Your Ref: OWPC20165
Our Ref: BR/219/18/PL 01-08-2018
Please ask for:
Mr S Davis

Demolition of 1 No. existing building & erection of 2 No. 2 bedroom & 2 No. 1 bedroom dwellings.

9 Westloats Lane Bognor Regis

Project Proposed Site Plan	Sheet 1
Date 2nd May 2018	
Scale 1 : 500

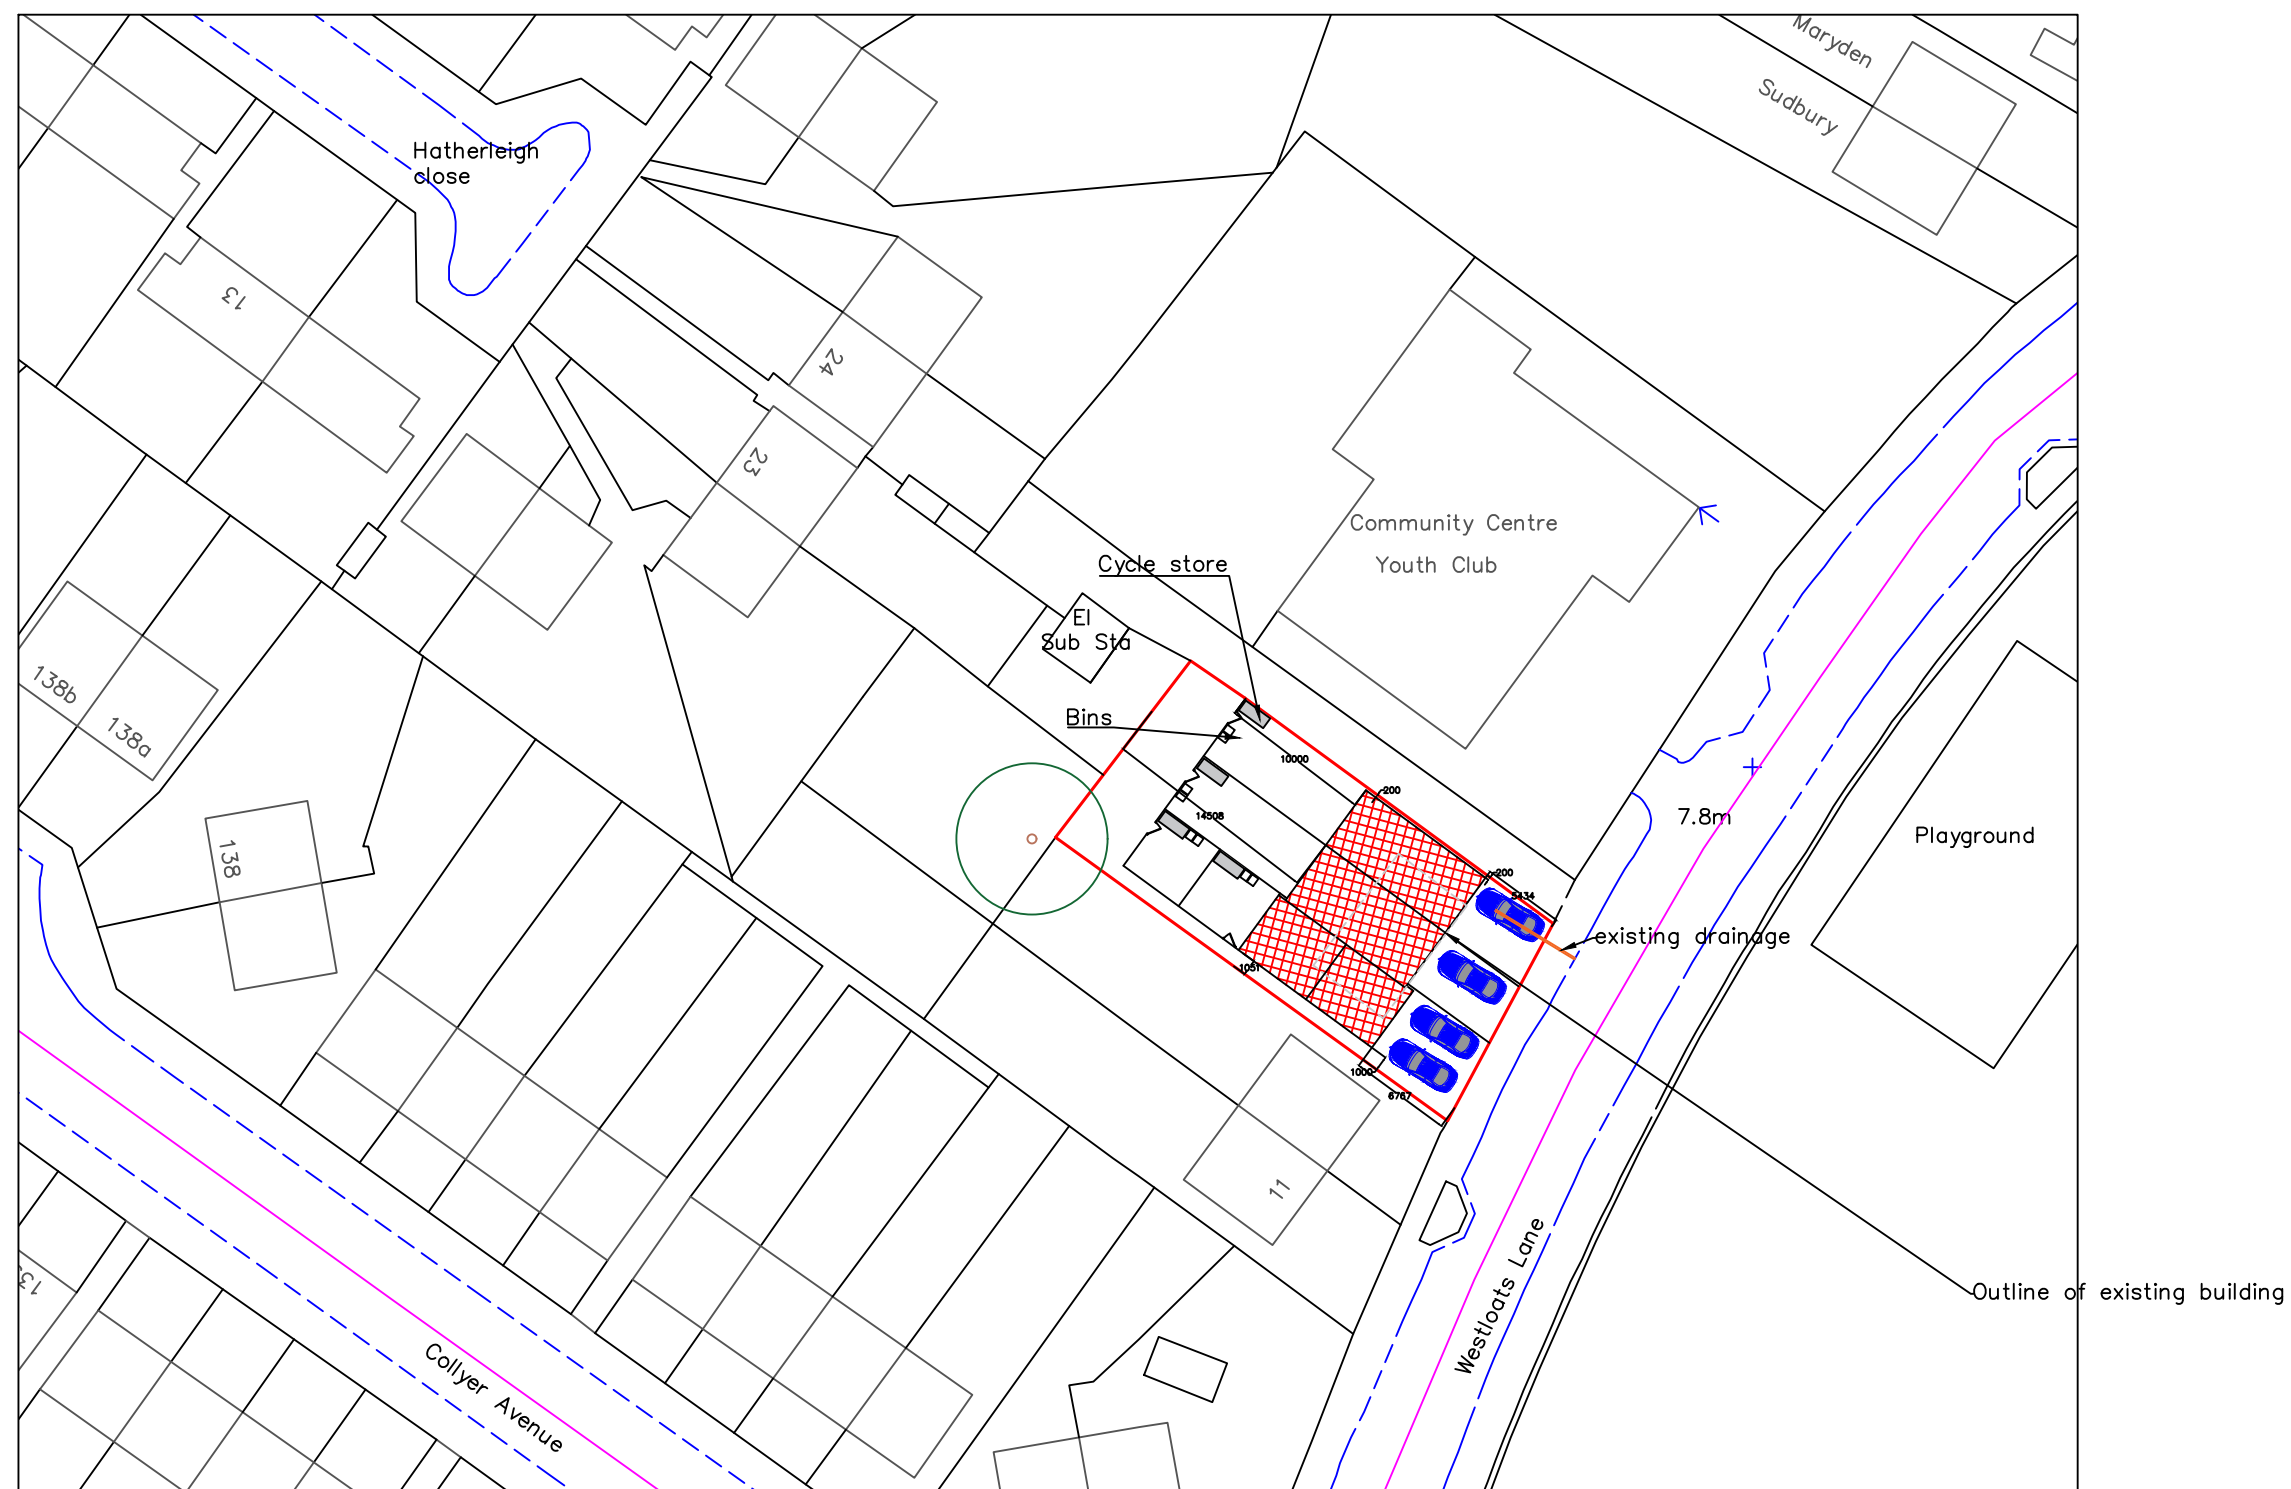
I also note there are also no proposals in the Landscaping Strategy for screen planting to lessen the impact of these buildings on adjoining properties and there is also an outstanding query as to the use of an area of land at the rear of the new dwellings' gardens and back edge of the site on which the site hut is currently located, which is near my garden boundary.

First Floor Plan

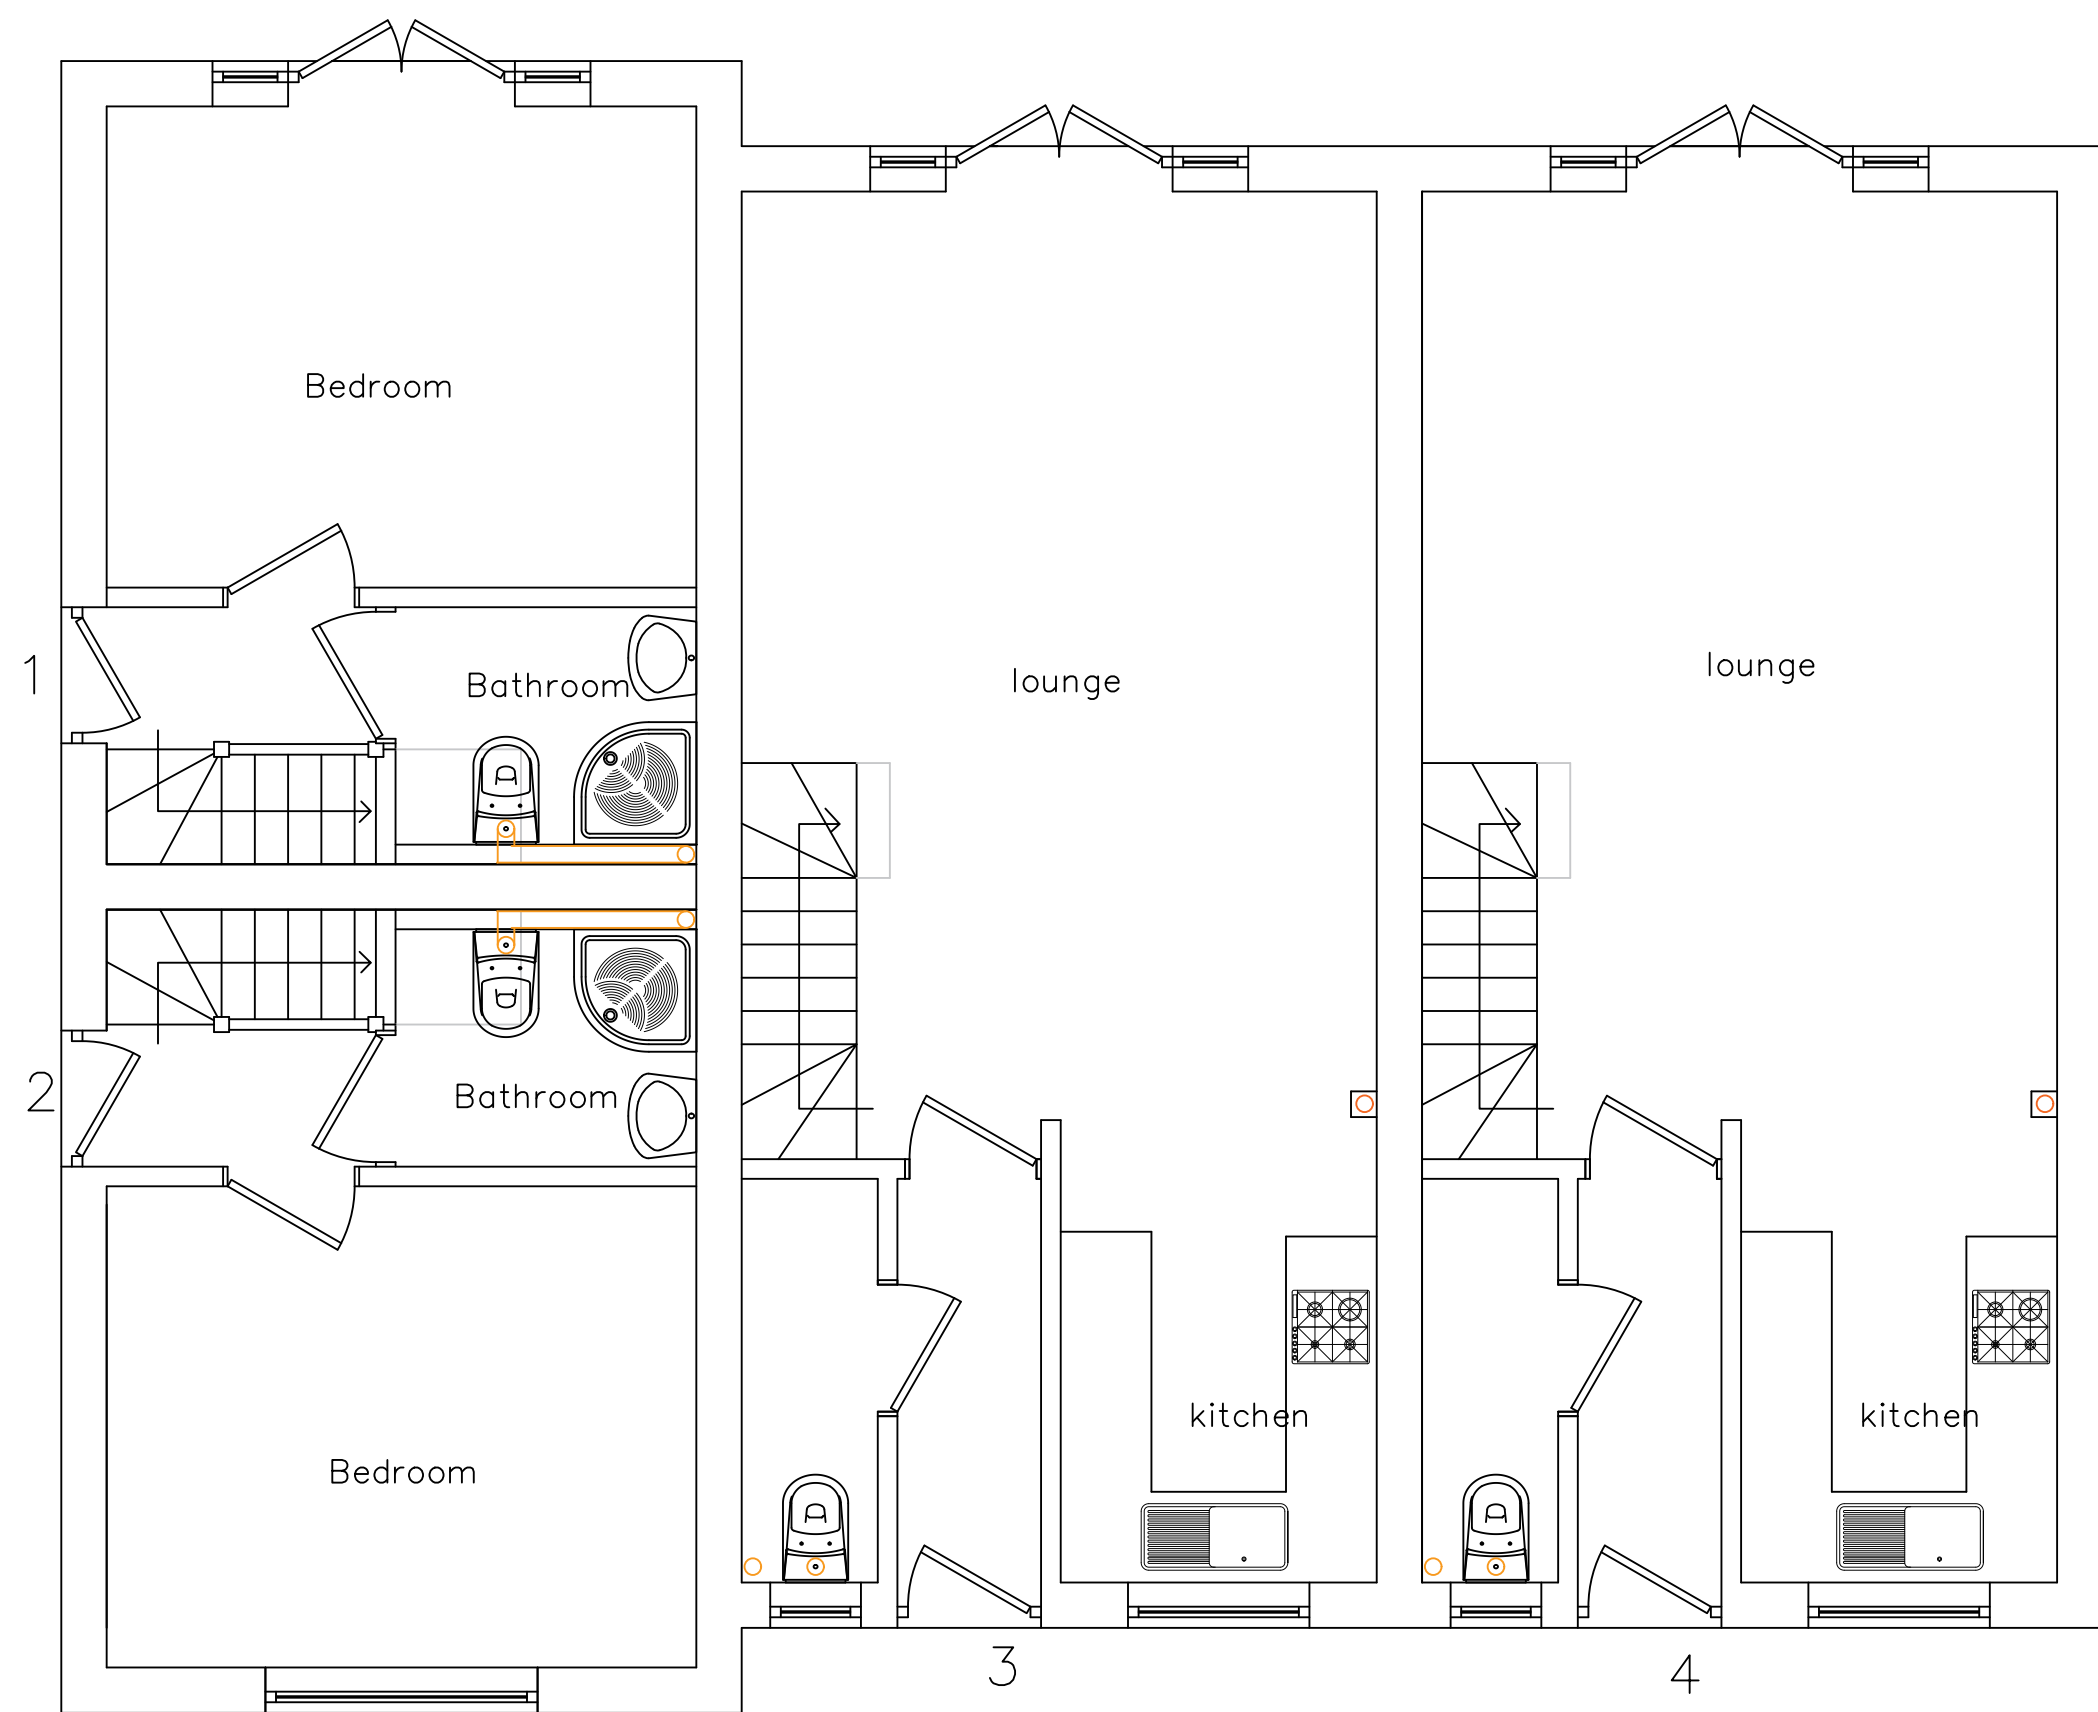
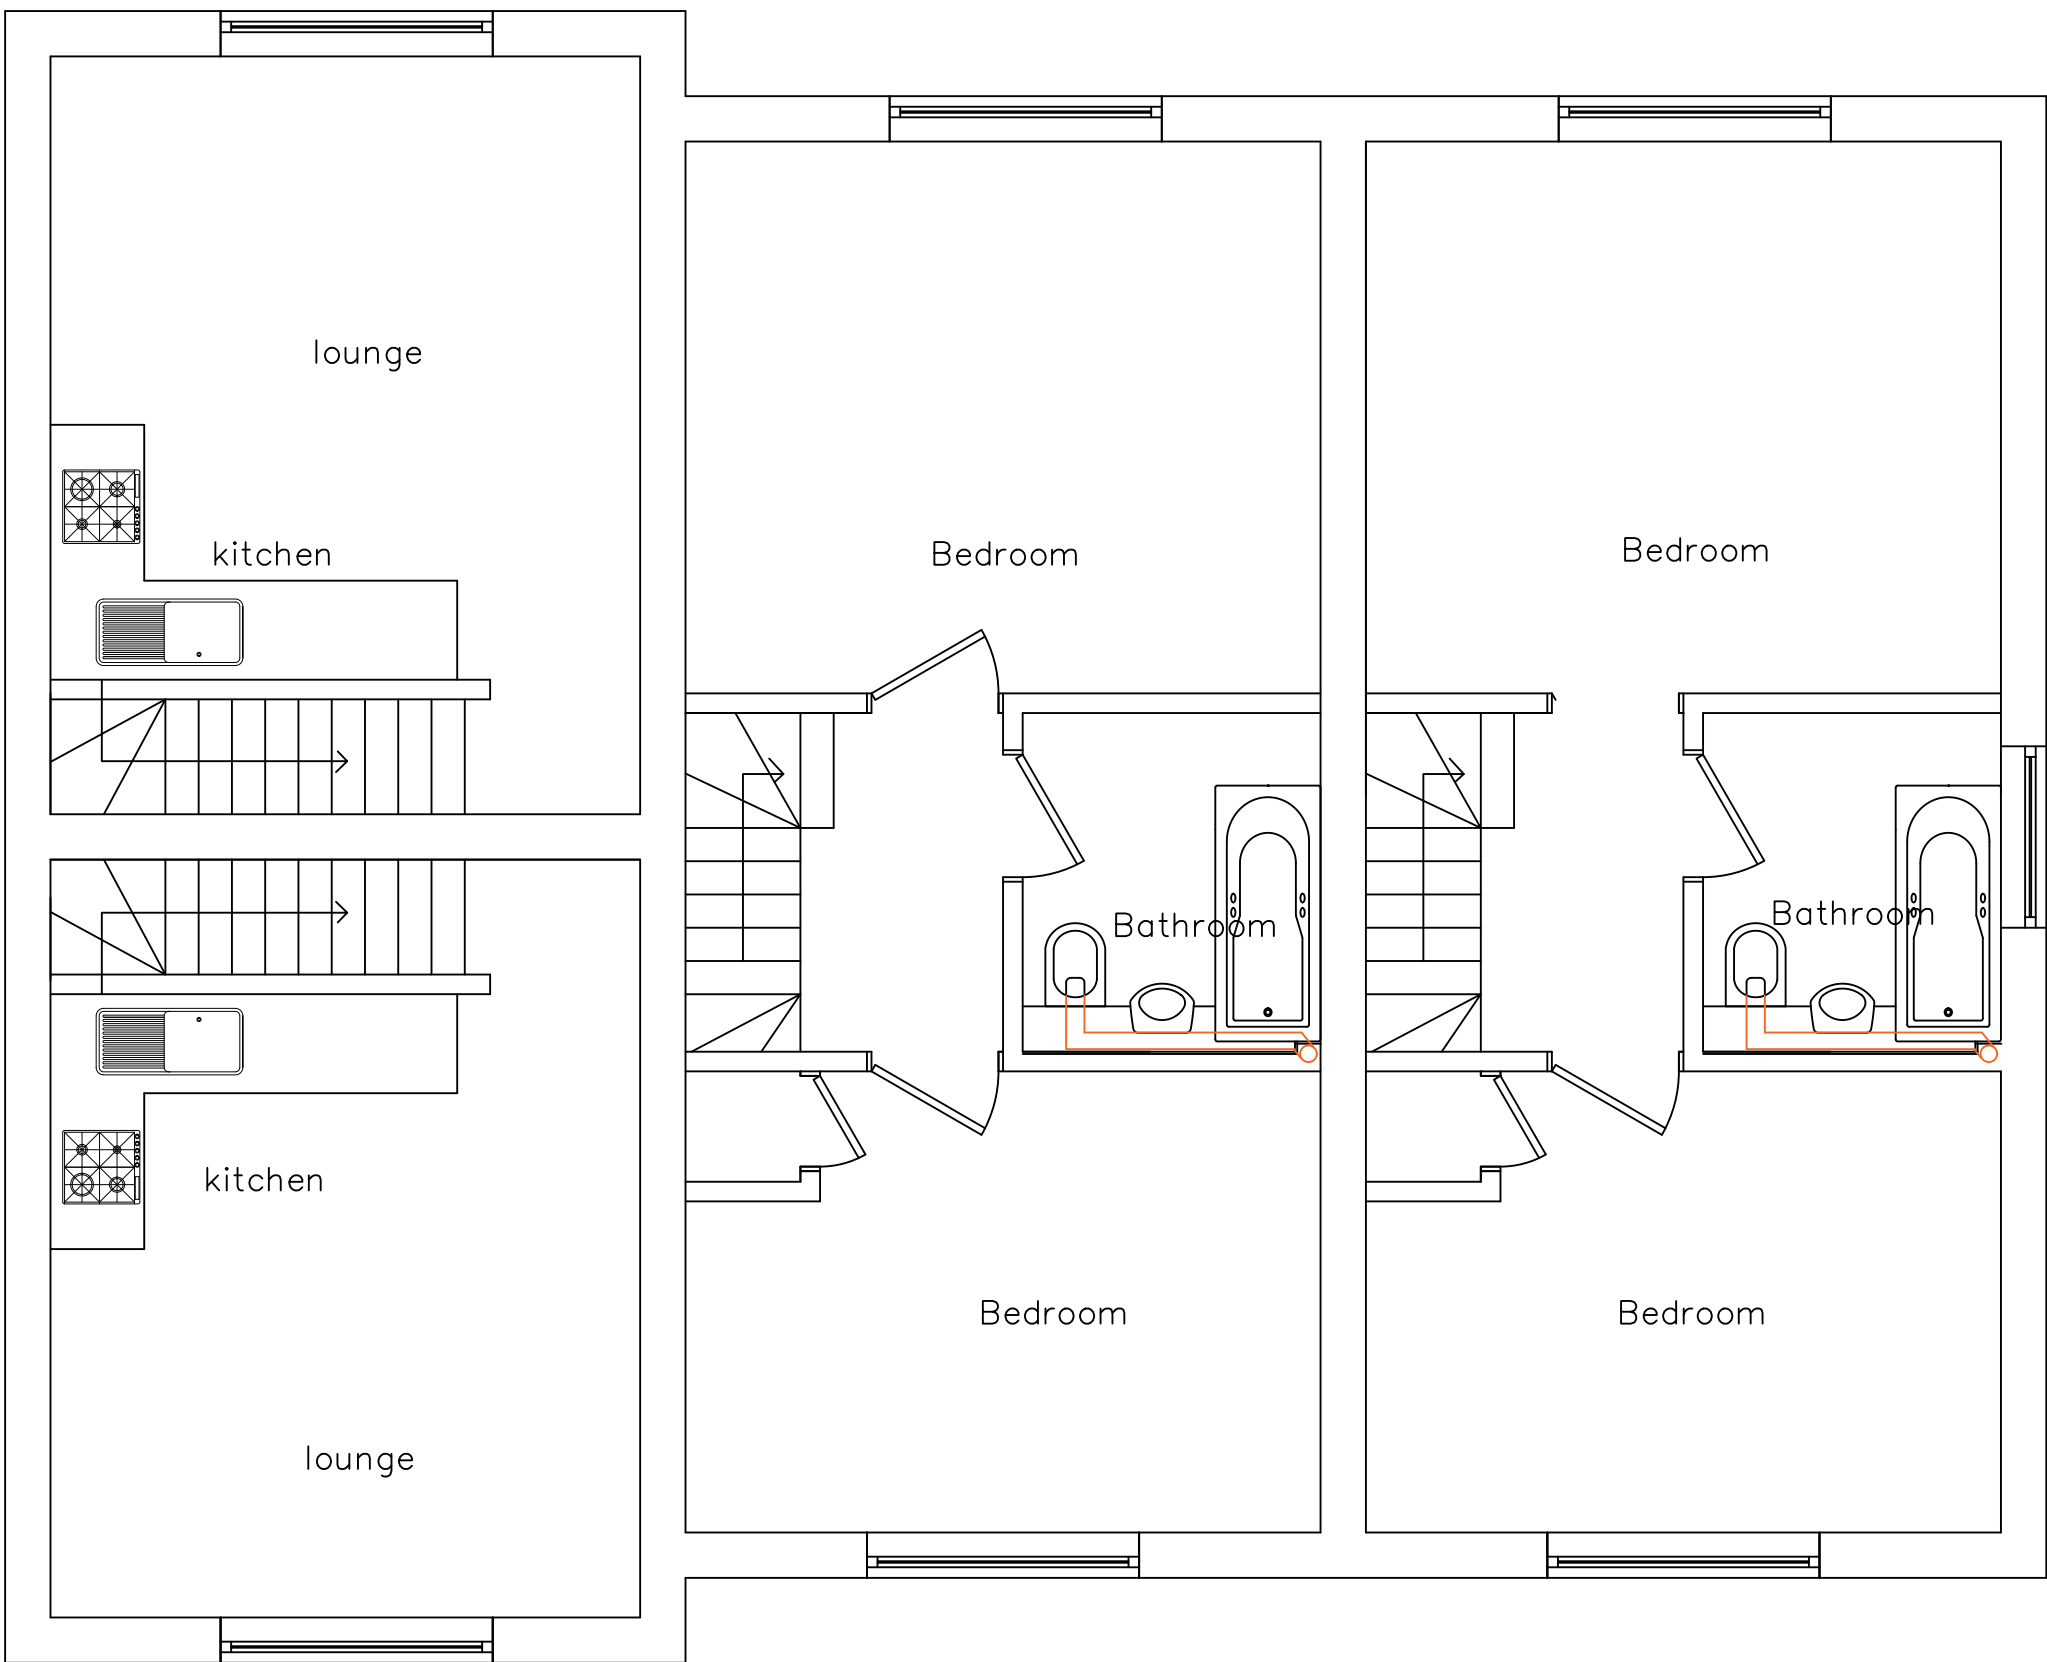
The applicant states in the Design Access Statement that the building has been designed so as not to overlook adjoining properties - however this is not the case as the proposed development's footprint is double the size of the existing structure and is situated towards the rear of the site to allow for parking at the front. I am concerned that the upstairs windows of the proposed development will overlook the rear bedroom windows of my property, the French doors and the patio area which are in daily use.

The existing property only has one upstairs window currently overlooking the rear garden which is the bathroom window and is glazed with obscure glass. This is clearly visible from my property and I am particularly concerned by the upstairs lounge window of the one bedroom dwelling which is facing into the garden area and the back of my property. This will be the main habitable area for the residents and will be in constant use.
